NORTH LINCS S51 ADVICE – EST INPUT – 12 April 2022

Environmental Statement (ES) (Volume 6)

Title Designated and Non-designated Heritage Assets Within 1km of the Order Limits

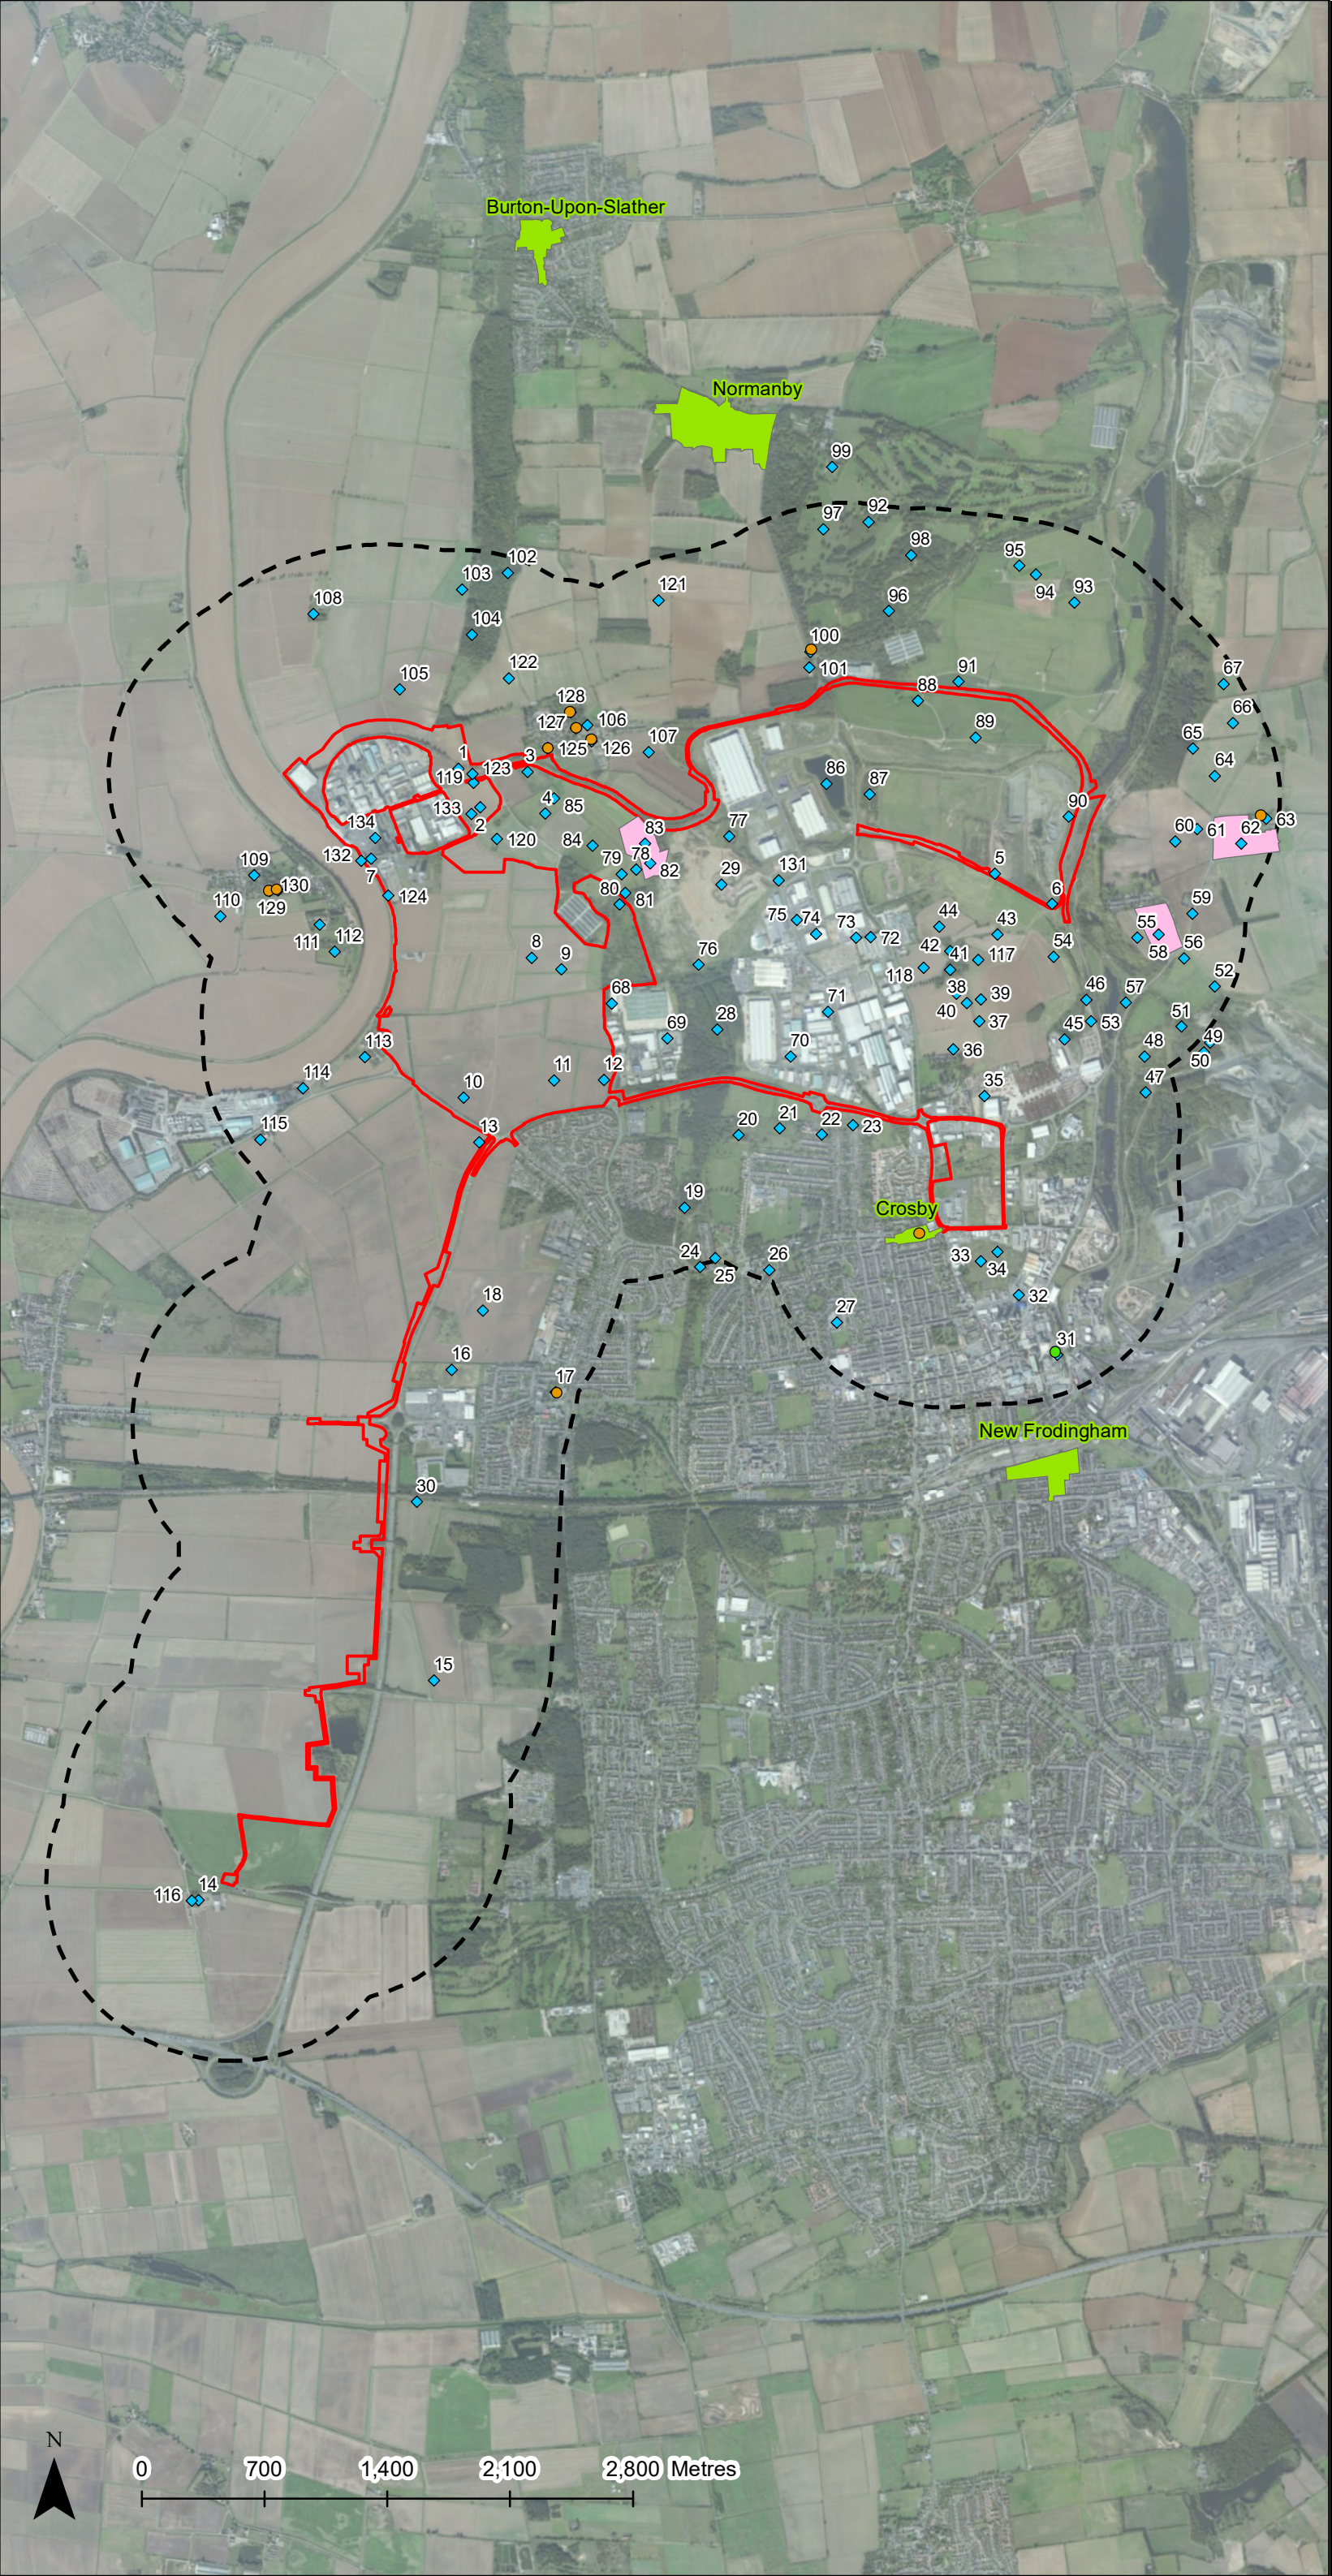
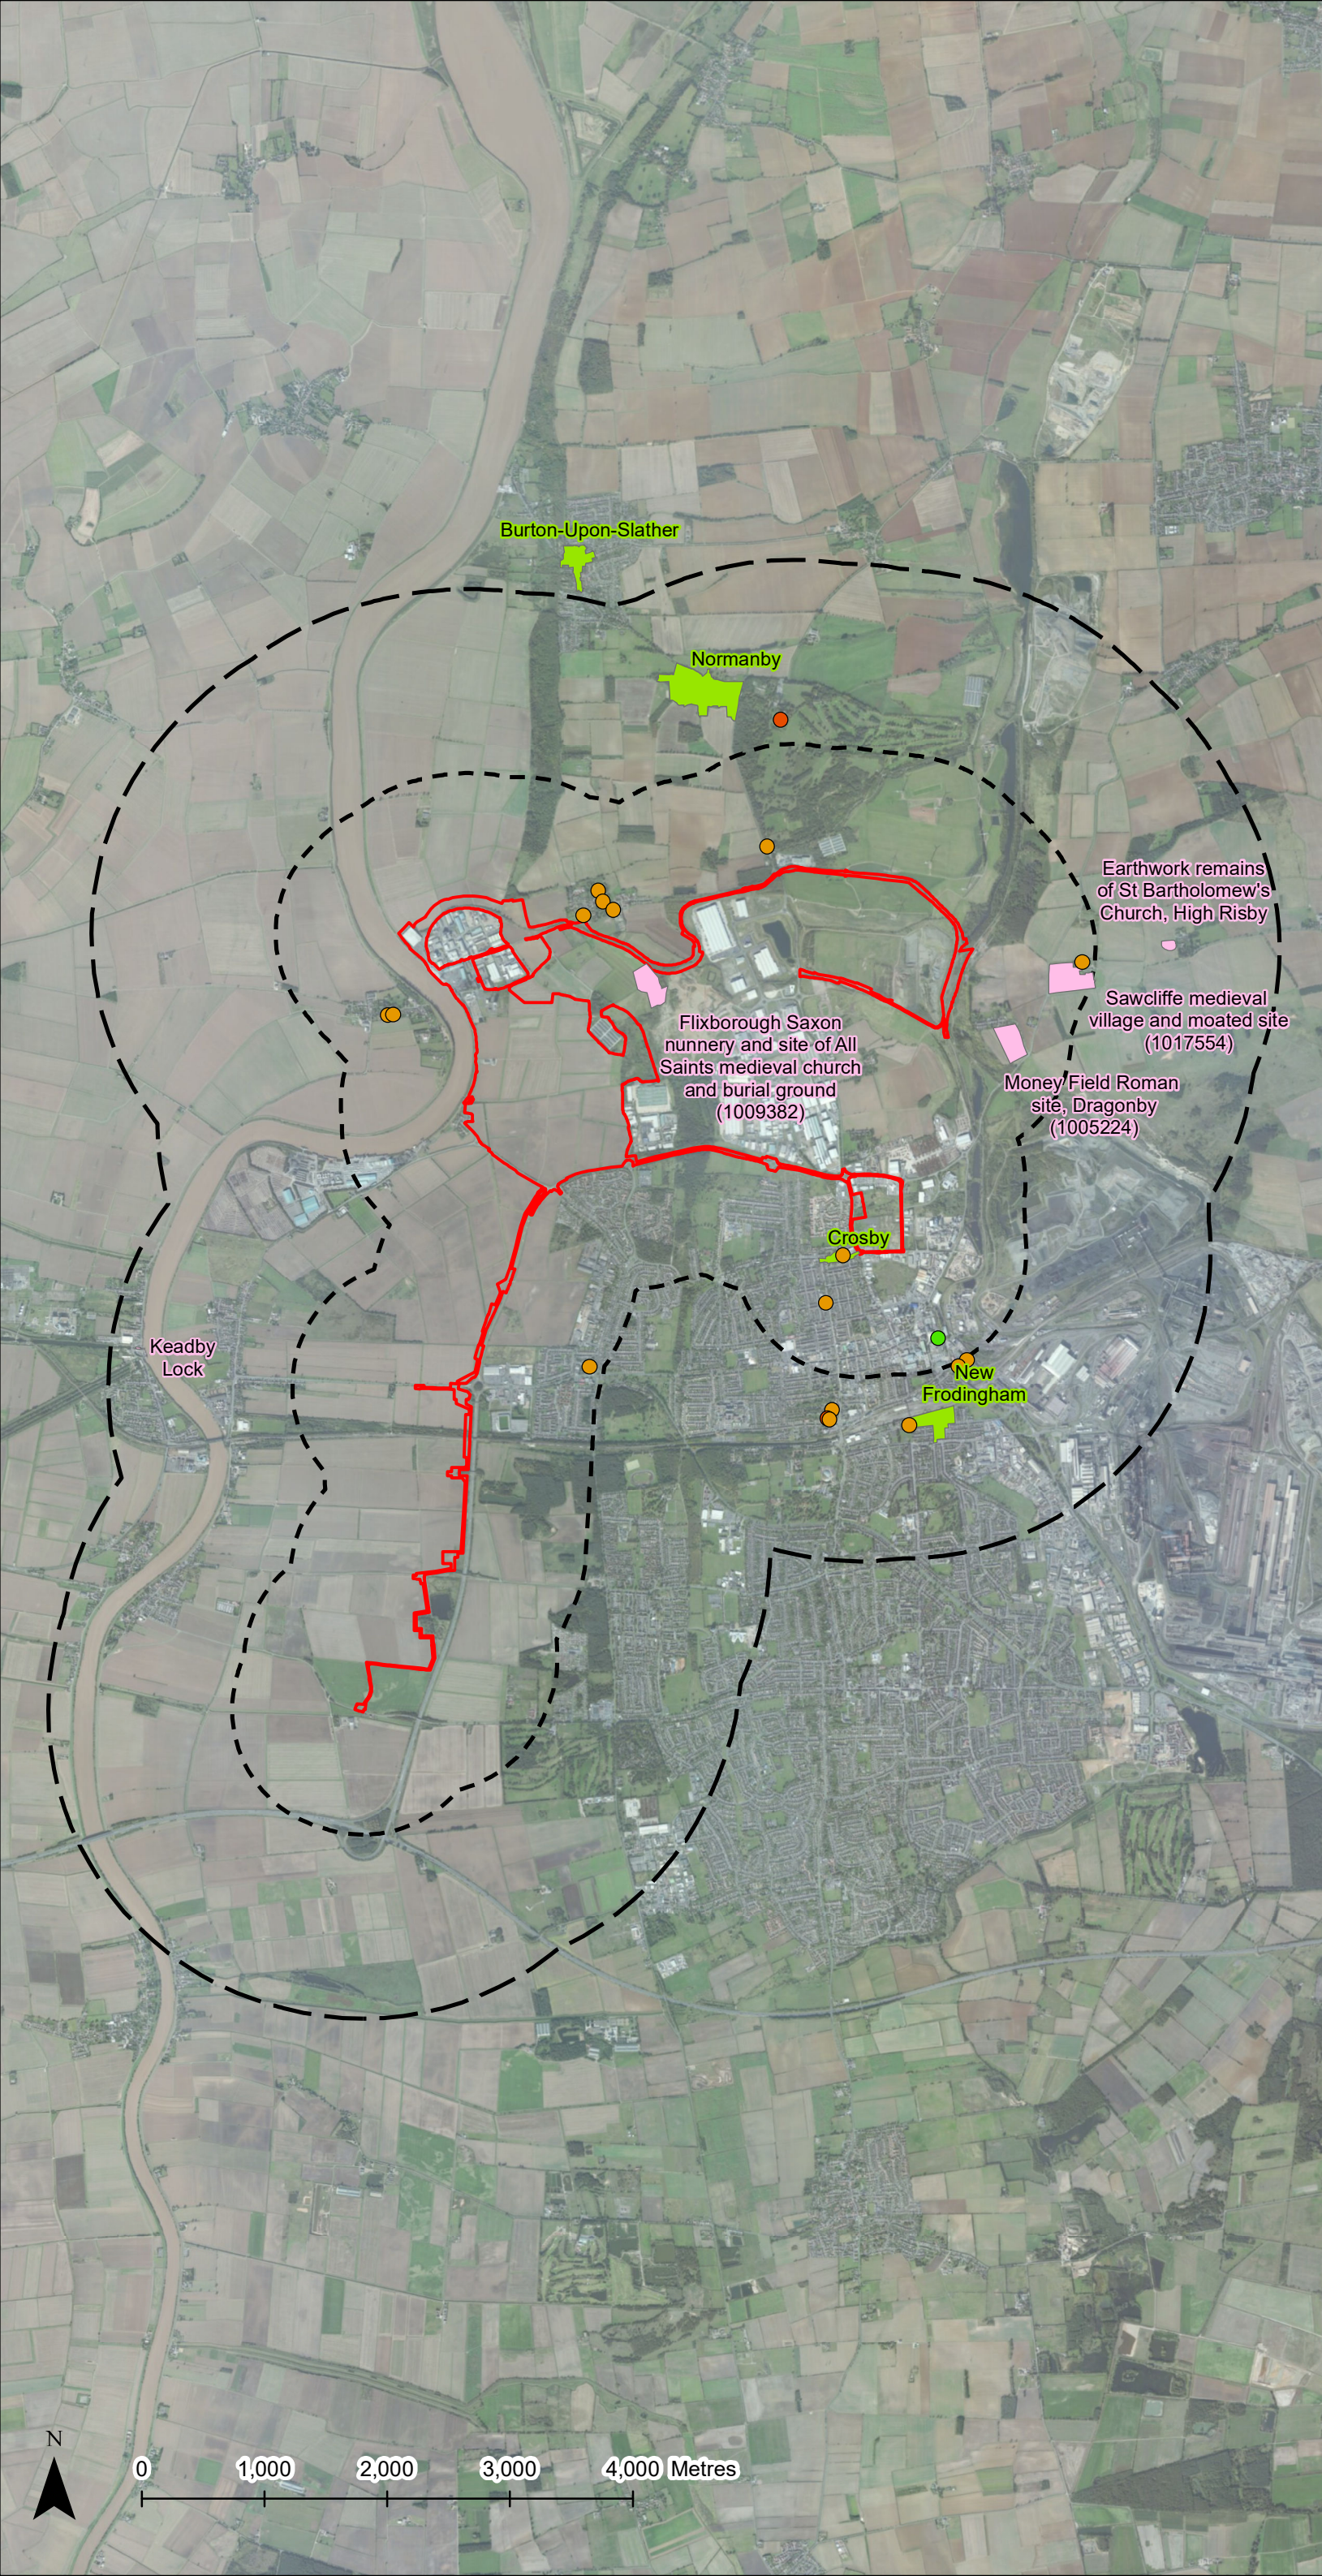
The plans in Document 4.7 do not identify all designated heritage assets that have been assessed within the ES. In addition, relevant plans provided within the ES are missing designated heritage assets that are identified on MAGIC map. Document 4.7 also incorrectly categorises some designated heritage assets as non-designated heritage assets. The Inspectorate advises the Applicant to redraft these plans to correct these errors.

The Inspectorate also notes that the plans identify features within a 1km buffer zone, which does not cover the full extent of the 7.5km study area applied in the ES with regard to impacts on setting. The Inspectorate advises the Applicant to ensure that the plans in Document 4.7 encompass the study area identified in the ES.

Roof Plan

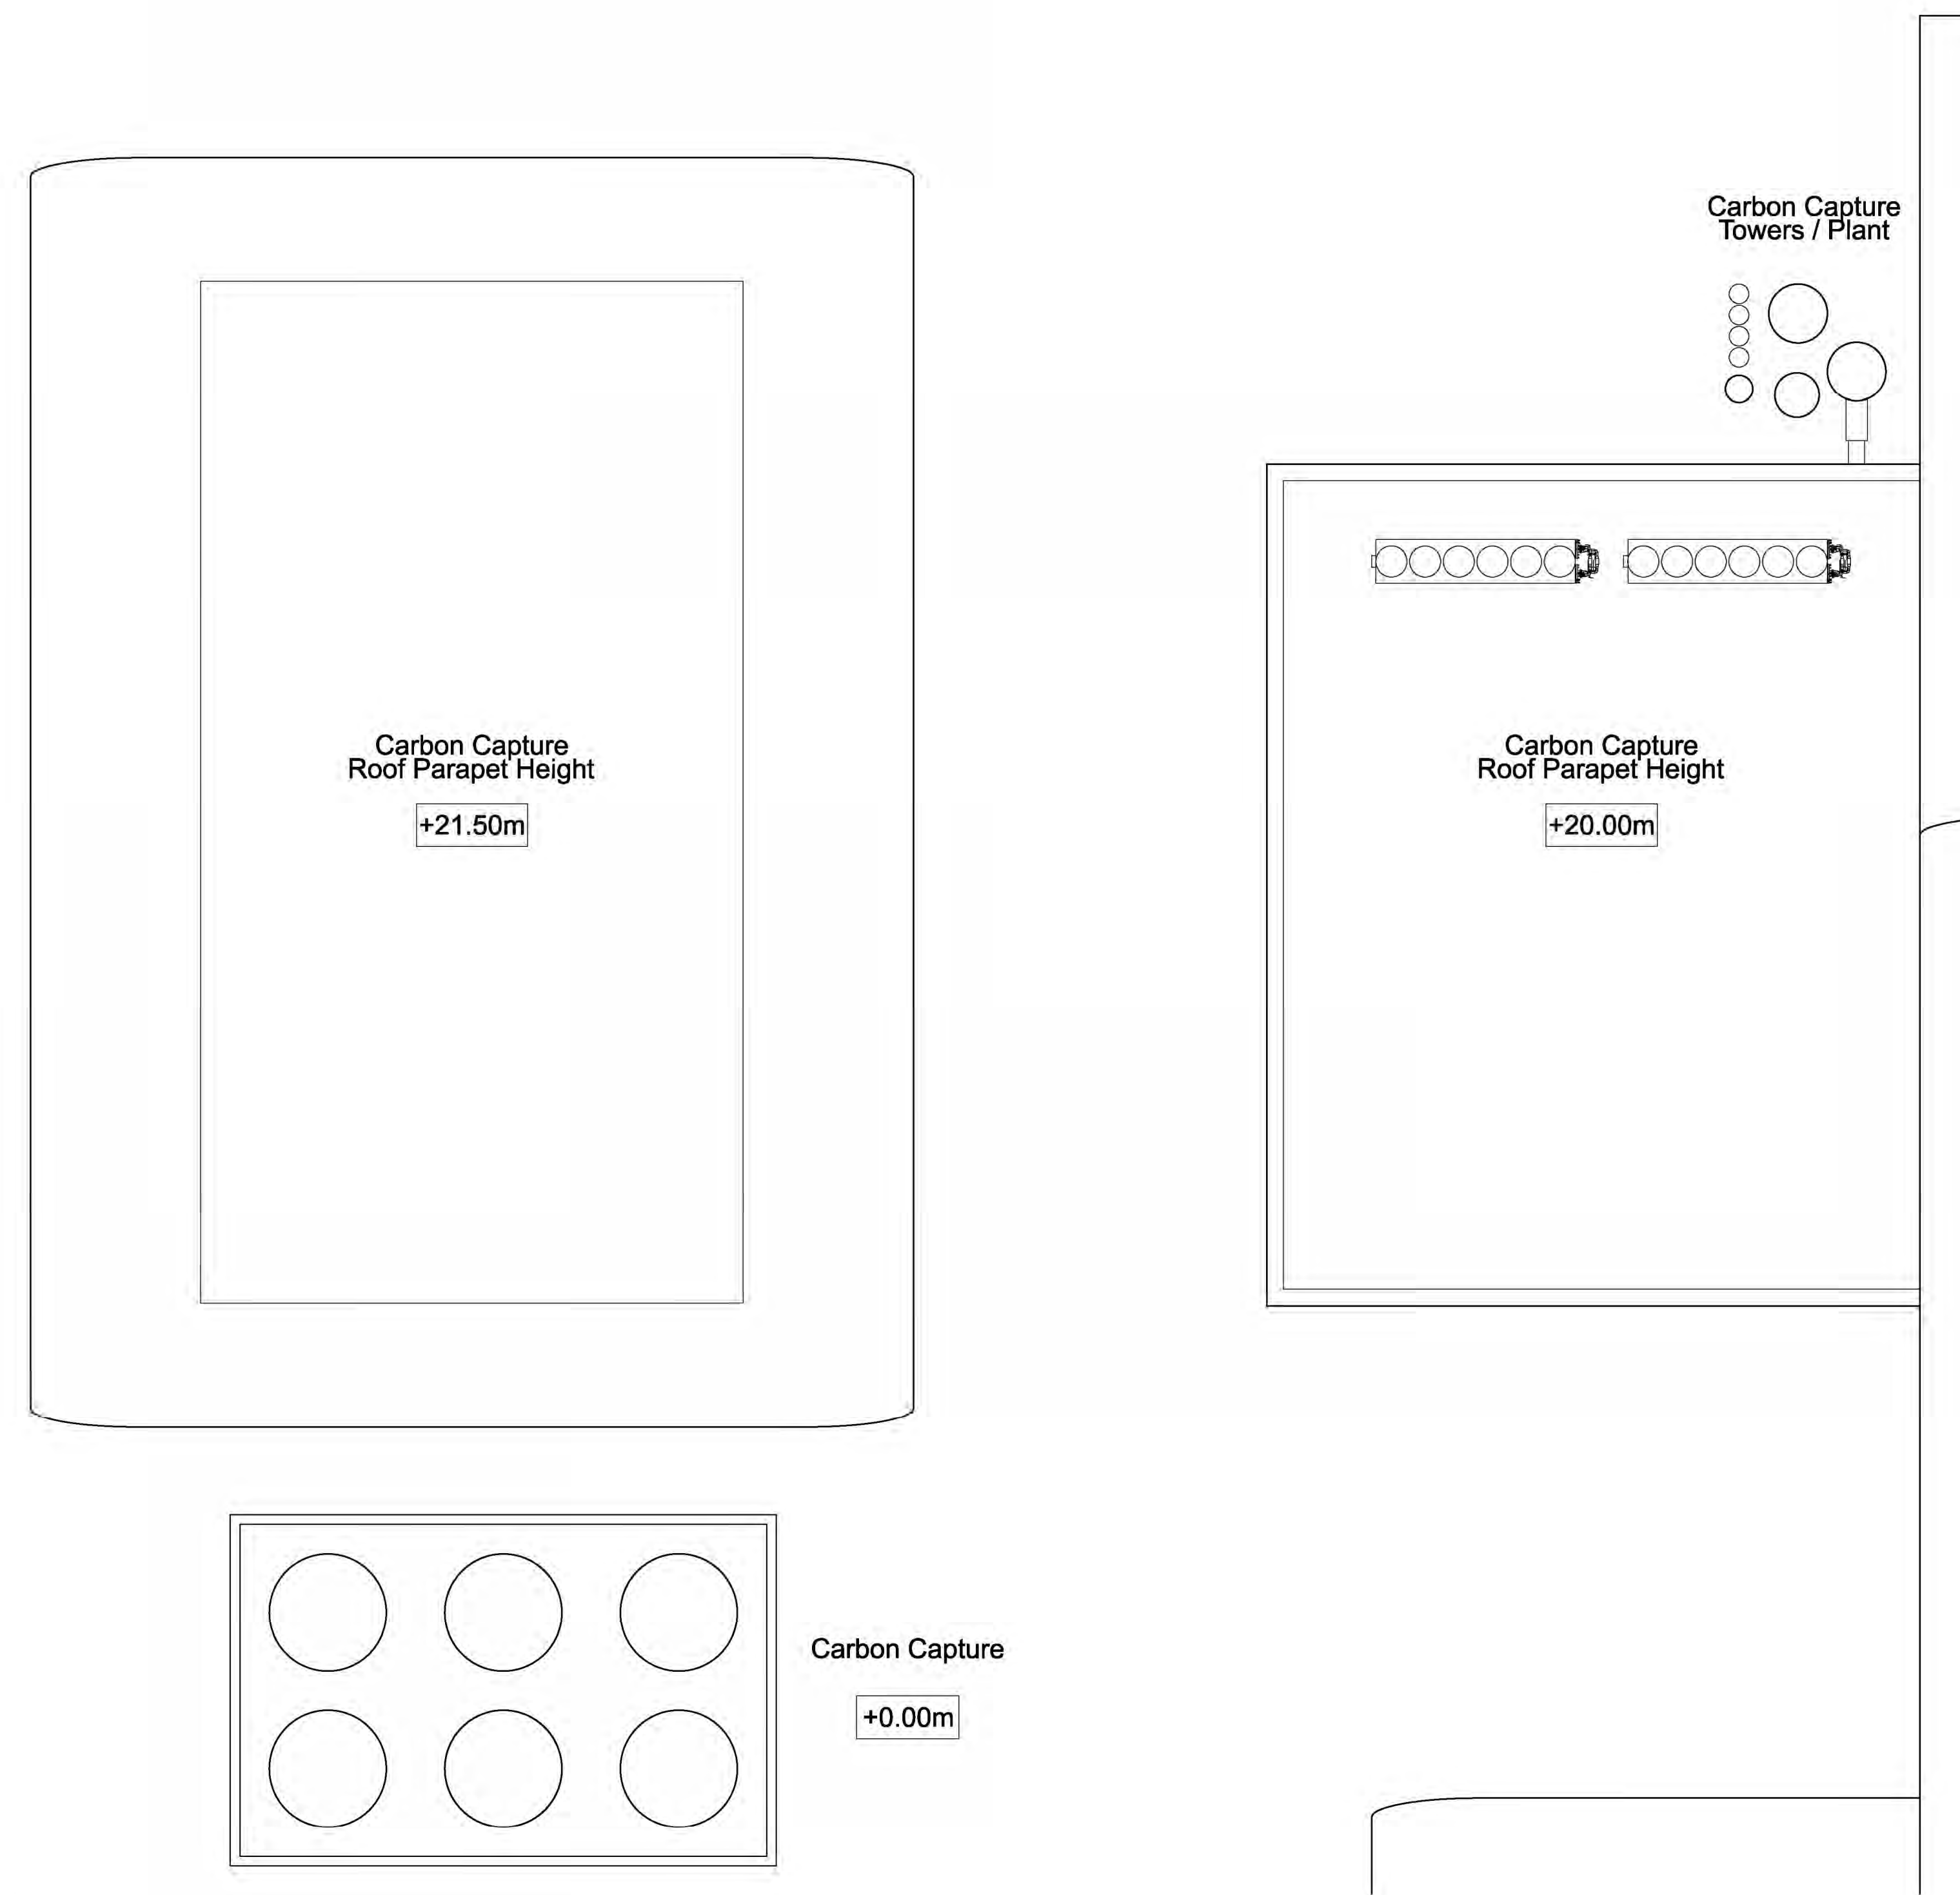
- The Works Plans show three stacks in three different locations.
 - The Roof Plans show a single main stack (enclosing three flues) and an additional back up boiler stack.
